15 September 2025

Our ref: D2025/106983

Mount Piper to Wallerawang Transmission Project (SSI-70279722) – EIS

Figure E.2c - Key project features

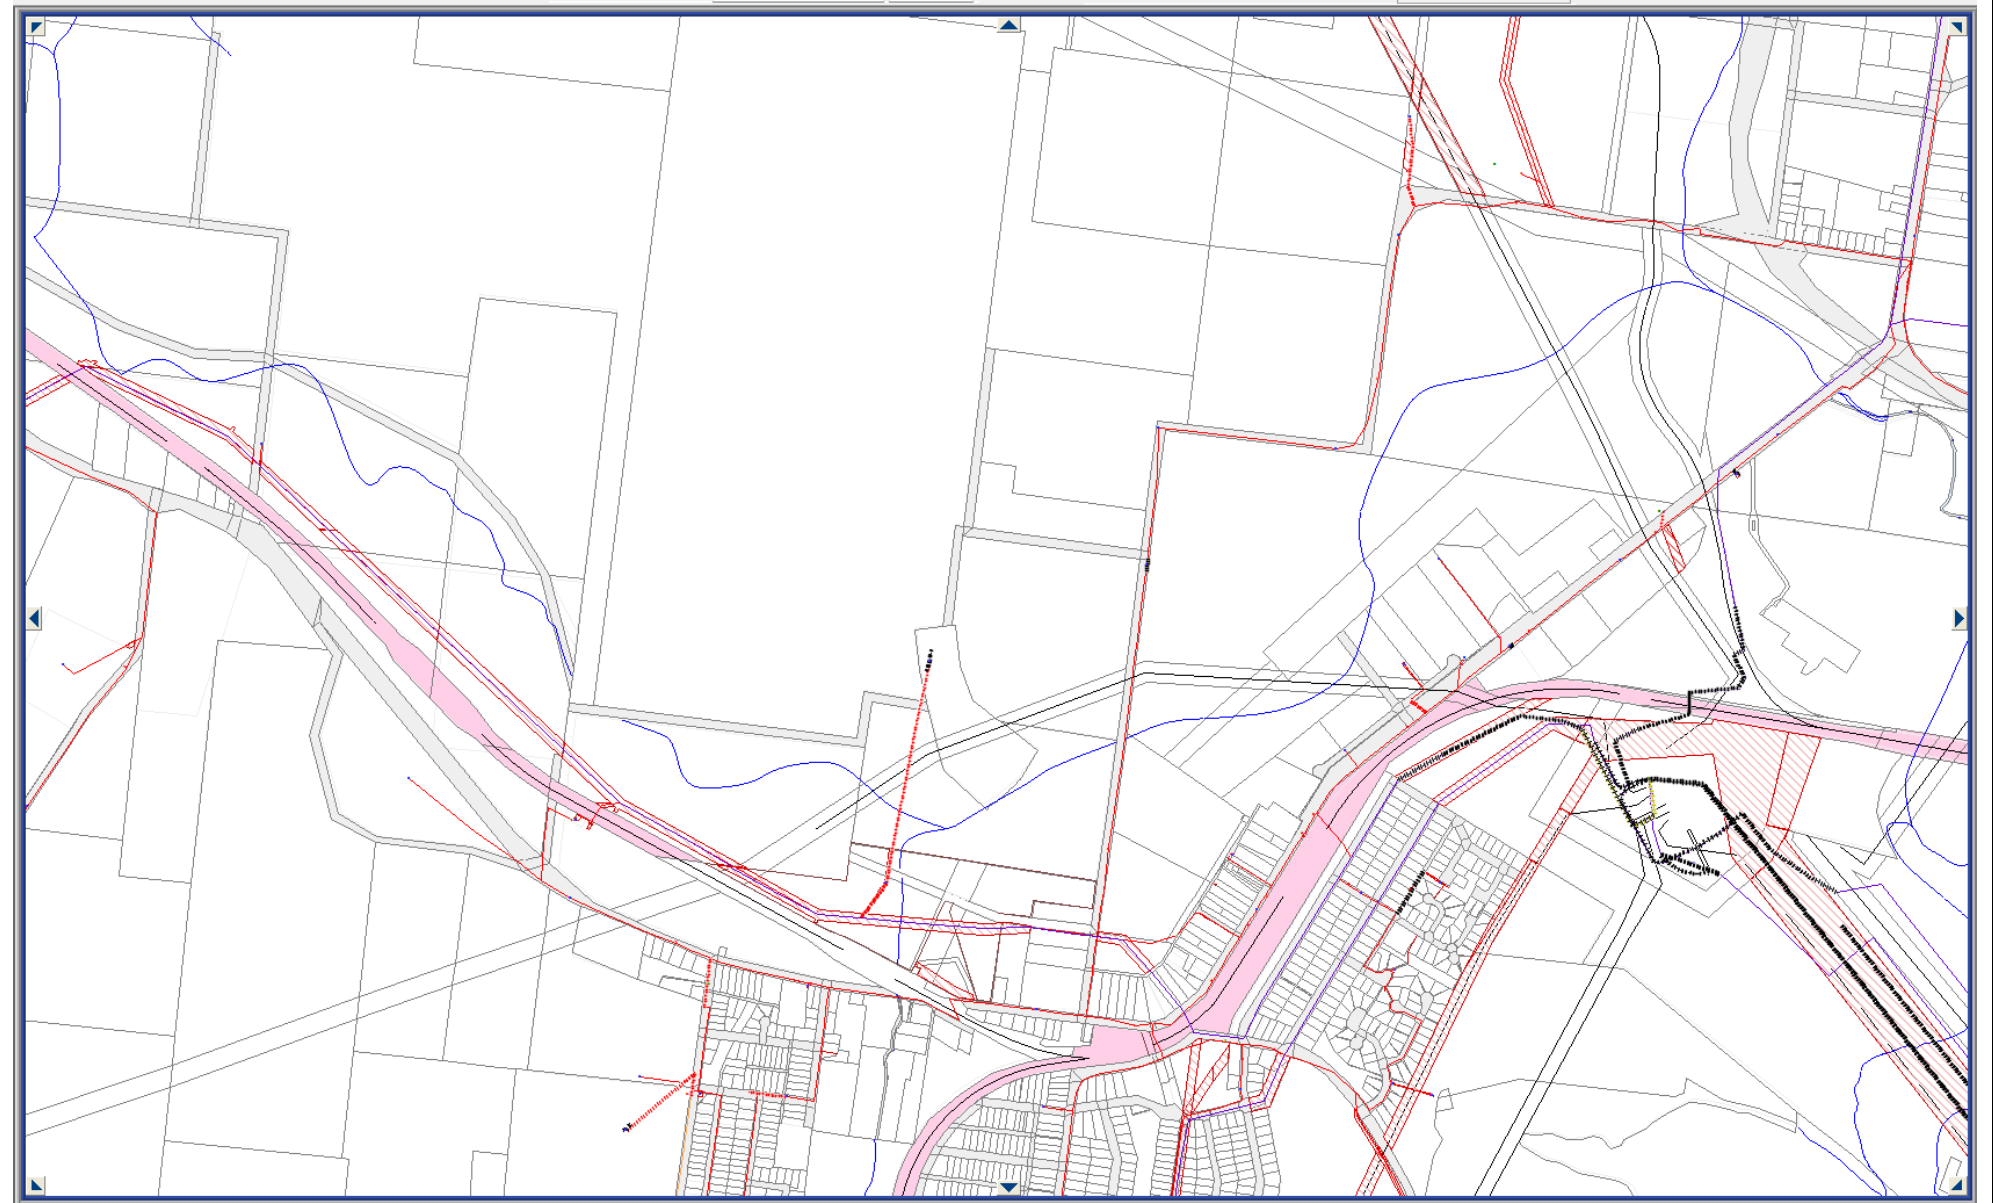
Of greatest concern to WaterNSW is where the project access tracks cross over the shallow pipeline, especially around access point 4 and at construction compound 1. Any interaction with this pipeline or system components has the potential to disrupt WaterNSW's ability to supply water to its customers (Oberon and Lithgow Councils, Mount Piper power station, and about 230 properties along its route), which poses a significant risk to WaterNSW.

The EIS has not adequately addressed the interaction with the Fish River Water Supply Scheme from construction of the project, nor nominated the risks or included appropriate asset protection measures. While consultation with WaterNSW is suggested, the EIS does not propose any specific protection measures. In our response to the SEARs (our ref: D2024/37611) we requested a detailed assessment of potential impacts to WaterNSW's Fish River Pipeline and associated assets and infrastructure, and WaterNSW's ability to access, operate and maintain these assets be included in the EIS. The EIS briefly describes the interaction with the Fish River Scheme at sections 3.5.3.2, 13.7, 13.3.7.1 and 13.4.2.6 as well as

- Loading over the pipelines (access tracks and construction compounds).
- Damage from vibration and ground movement.
- Electrification of the metal pipeline.
- Restrictions to WaterNSW access and egress.

- a) The Proponent must not impact the WaterNSW Fish River Water Supply Scheme.
- b) Through ongoing consultation and prior to construction commencing, the proponent must confirm with WaterNSW any specific asset protection requirements for use of access tracks, laydowns or construction compounds in the vicinity of the Fish River Scheme. Details of any specific requirements must be included in the Traffic and Transport Management Plan.
- c) The Proponent must ensure unobstructed access to all components of the Scheme is maintained for WaterNSW during both the construction and operation.
- d) The Proponent must ensure that the project works are designed, constructed and operated in such a way that does not impact the environment or restrict WaterNSW from operating and maintaining the water supply scheme (including access to inspection points and scour valves). WaterNSW

- e) Prior to construction commencing, the proponent must enter into an agreement with WaterNSW for access and use of WaterNSW Lot 1 Deposited Plan 567915.
- f) Unless otherwise agreed with Water NSW, the project must not trigger the maximum allowable limits set within the German Standard DIN 4150 – Part 3 – Structural Vibration Part 3: Effects of vibration in structures, when measured at the Fish River Water Supply Pipeline or another agreed location.
